Our Ref: 2023/130312
File No: R/2016/41/G

Harbourside Shopping Centre Redevelopment – Advice on Modification 3

Thank you for your correspondence dated 3 March 2023 inviting the City of Sydney Council (“the City”) to comment on the above modification to the Concept Approval (SSD 7874, as amended).

1 Shadow Projection JUN 900
9am

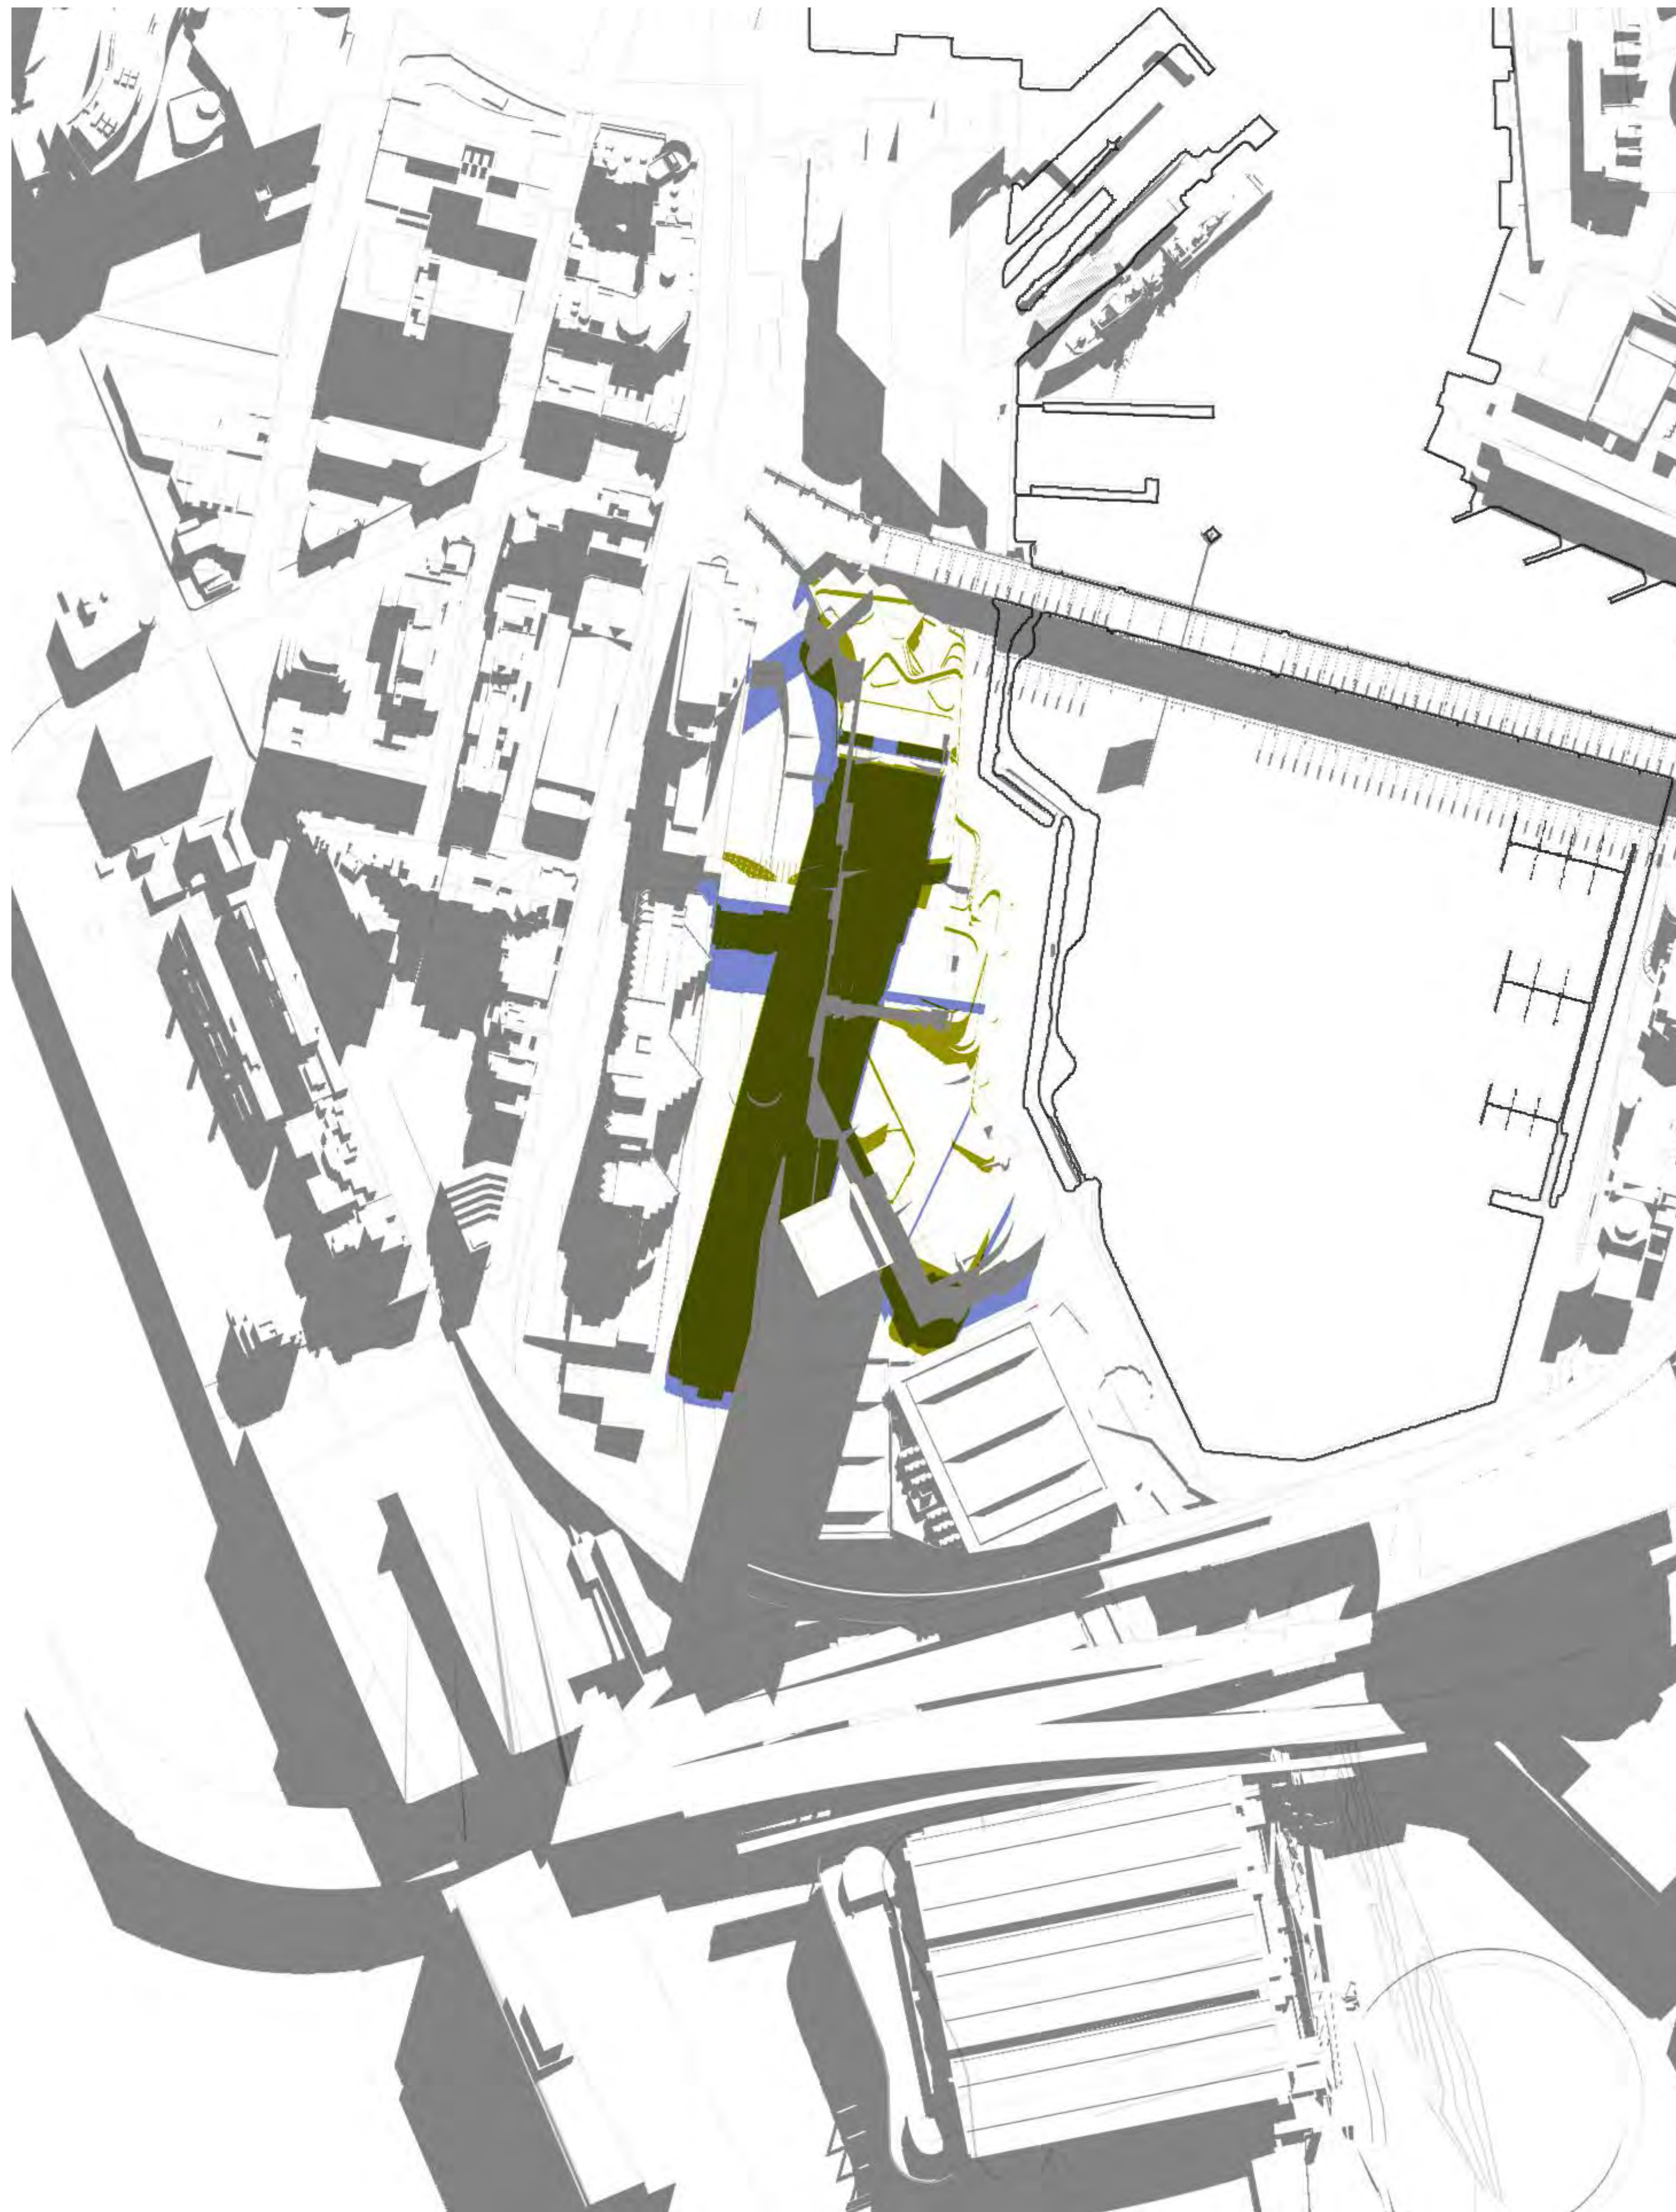
It is noted that the City raise no objection to the proposed envelope height, however it must not exceed RL 170, as although there are some minor additional overshadowing impacts at 9am to the housing located on Harris Street and the rear of terraces located on Jones Street, it appears that by 10am the shadow has passed, and that these sites are already in shade from surrounding buildings. It is also within the planning envelope.
